**WELWYN HATFIELD BOROUGH COUNCIL
EXECUTIVE DIRECTOR - PLANNING, PUBLIC PROTECTION AND GOVERNANCE**

DELEGATED APPLICATION

Application No: 6/2015/2234/VAR
Location: Land off Comet Way, Hatfield, AL10 0XY
Proposal: Variation of conditions 2 (Plans) and 4 (Materials) of planning permission S6/2014/1443/FP - Erection of new public house and associated works
Officer: Mr S Dicocco

Recommendation: Granted

Drawing Title:
Proposed Floor Plans

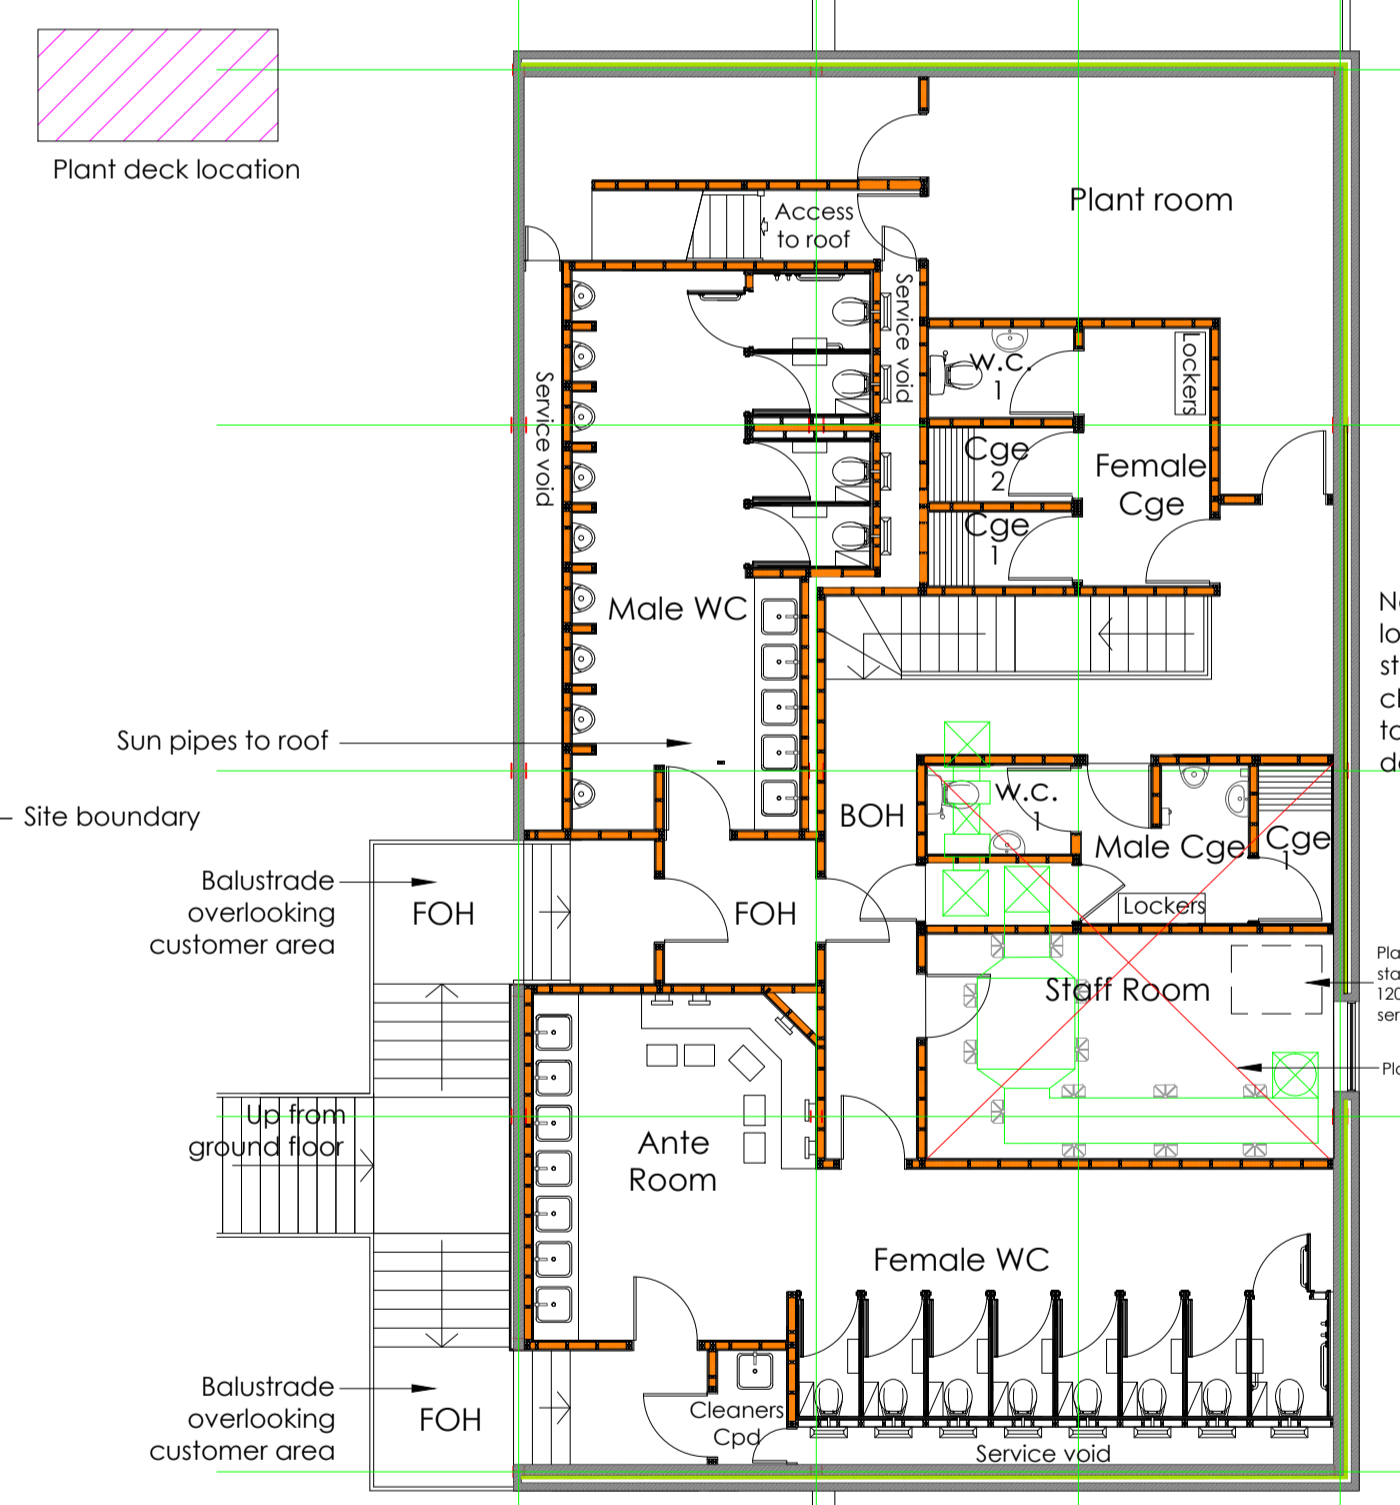
Comment (if applicable): The combination of external alterations to the building and landscaping as described above and depicted within the amended plans provided does not result in the building appearing out of context with the surrounding area. The building's proportions have not changed, and the alterations in terms of omissions and additions result in only minor alterations to the visual appearance of the building. As such, the building, as built, would comply with policies D1, D2 of the Welwyn Hatfield District Plan and Supplementary Design Guidance. In regards to the alterations in the amount, distribution and tree specification, it is considered unfortunate that the number and specification of the trees has been altered. Notwithstanding this, the trees have taken well and provide some screening within their positions. It is considered that

Drawing Title:  
Proposed Elevations

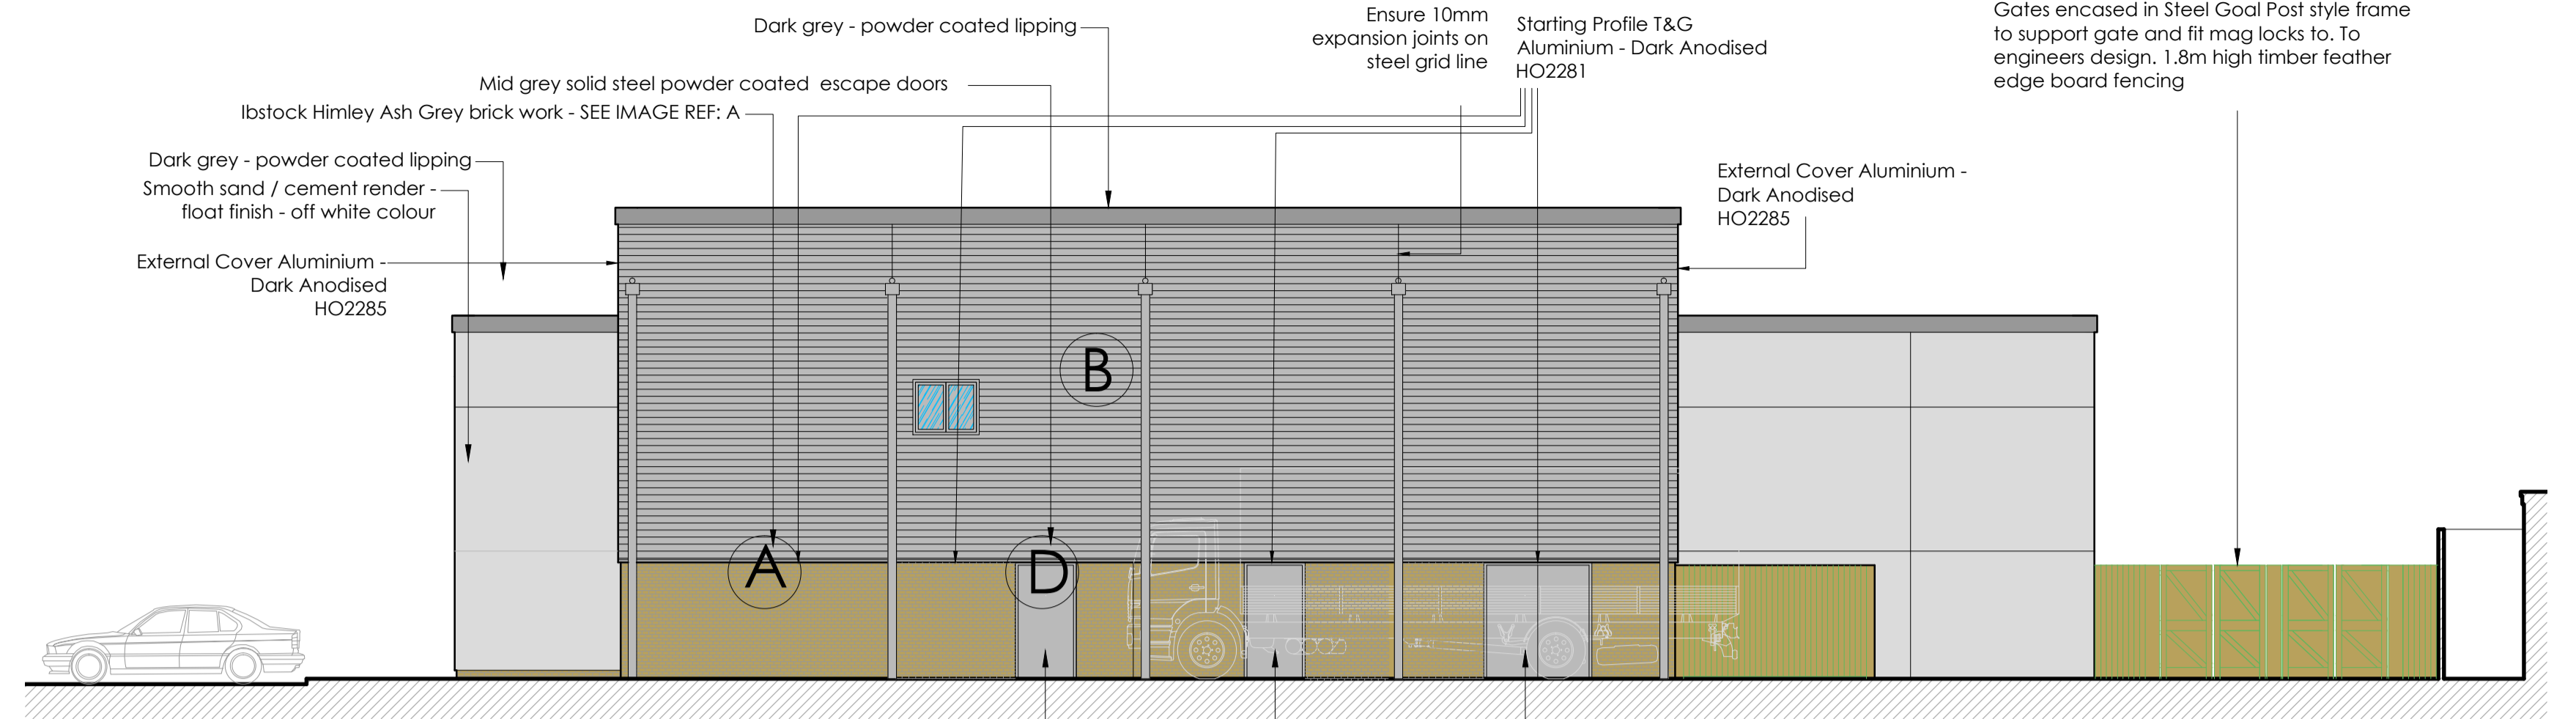
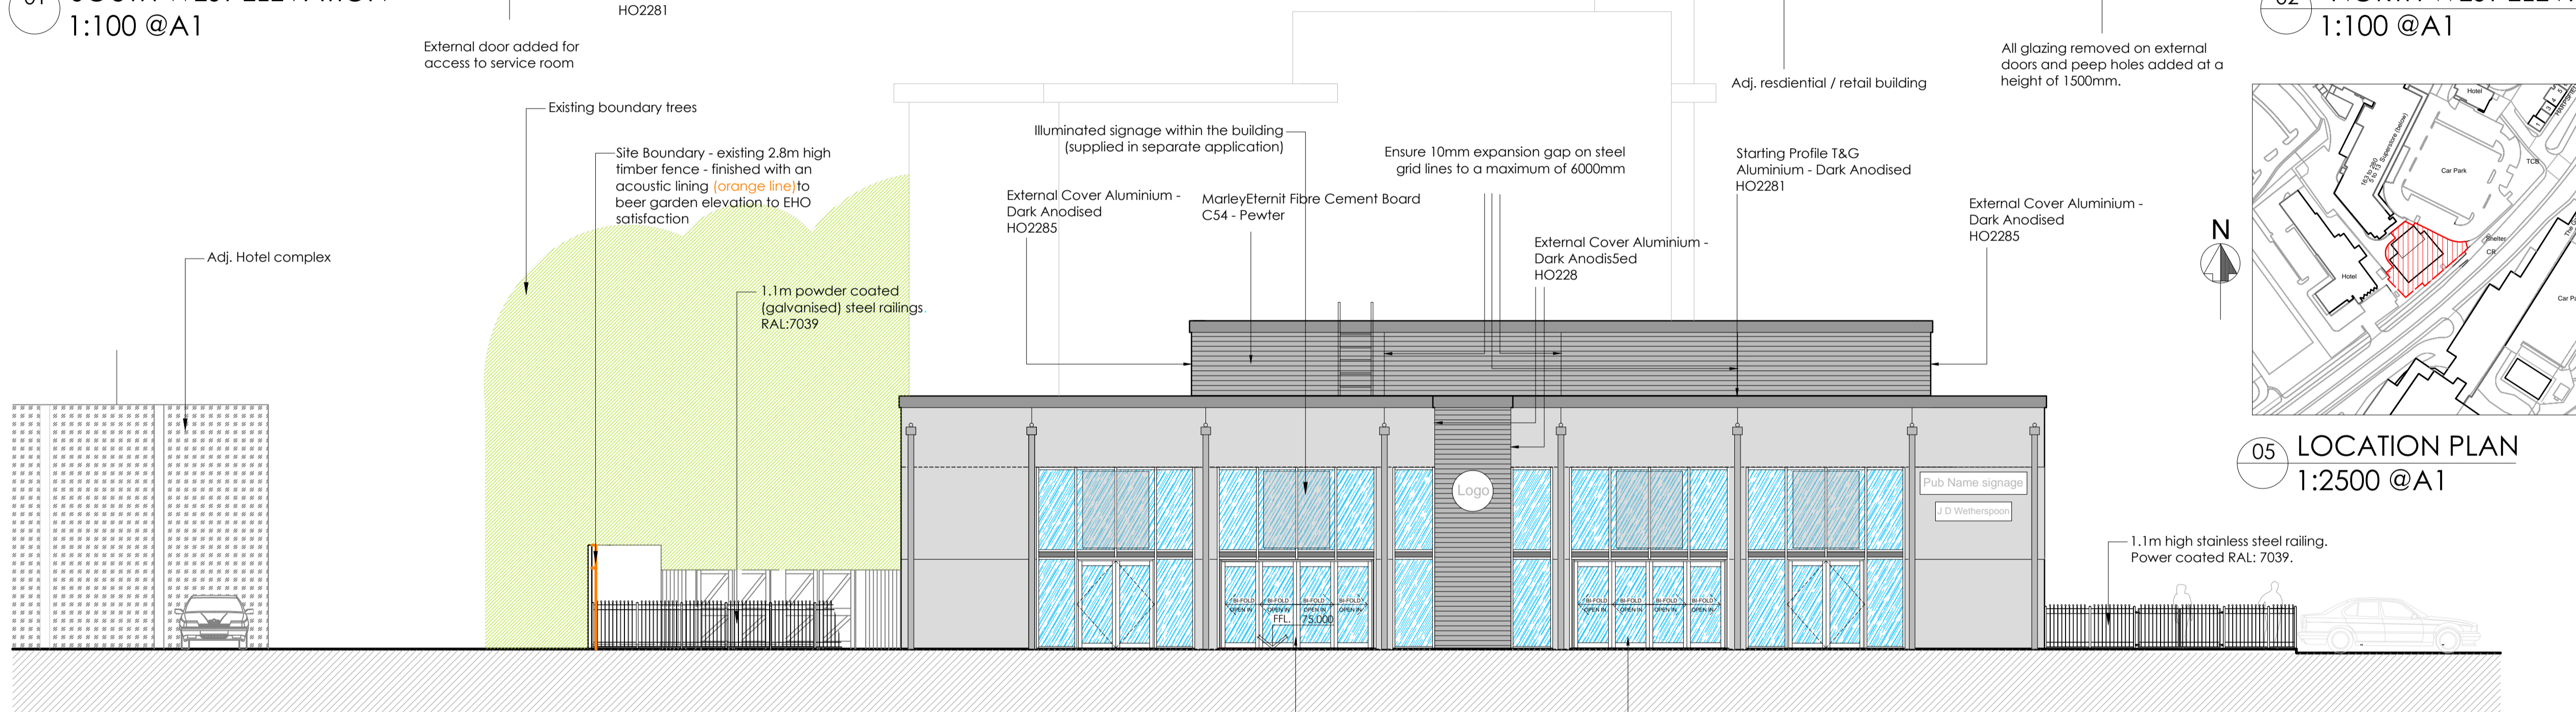
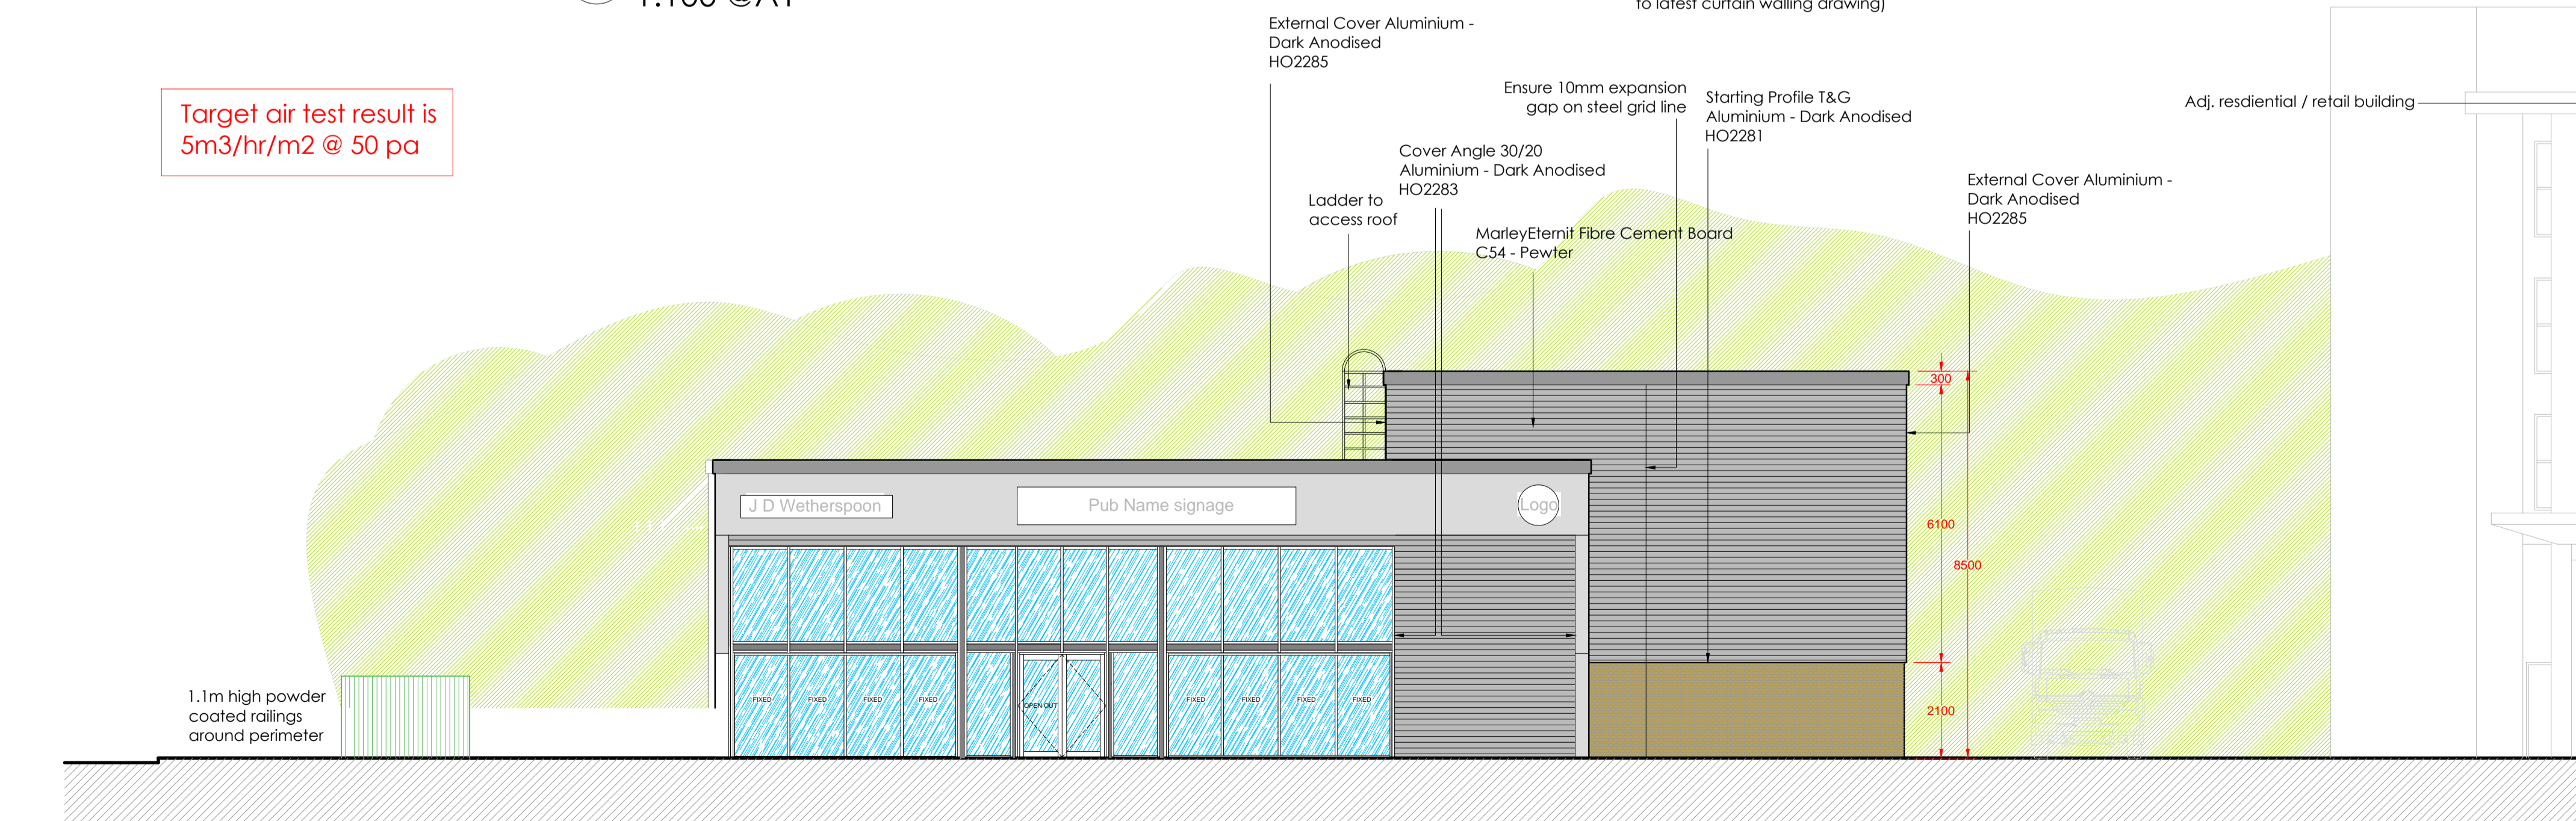
Comment (if applicable): The alteration which causes concern in relation to the amenity of the occupiers of adjoining premises is the installation of a first floor window serving the staff room within the north west elevation. The residential use at second and third floor level opposite this window hosts clear glazed windows. Notwithstanding this concern, the approximate 10m separation distance between the buildings, as well as the mismatch in position of the windows within the elevations would only result in oblique views from a distance between windows. Accordingly, privacy would not be unduly impacted by the window. The other alterations would have no impact on the occupiers of adjoining premises. As such, the variations accord with policy D1, R19 and R20 in this regard.
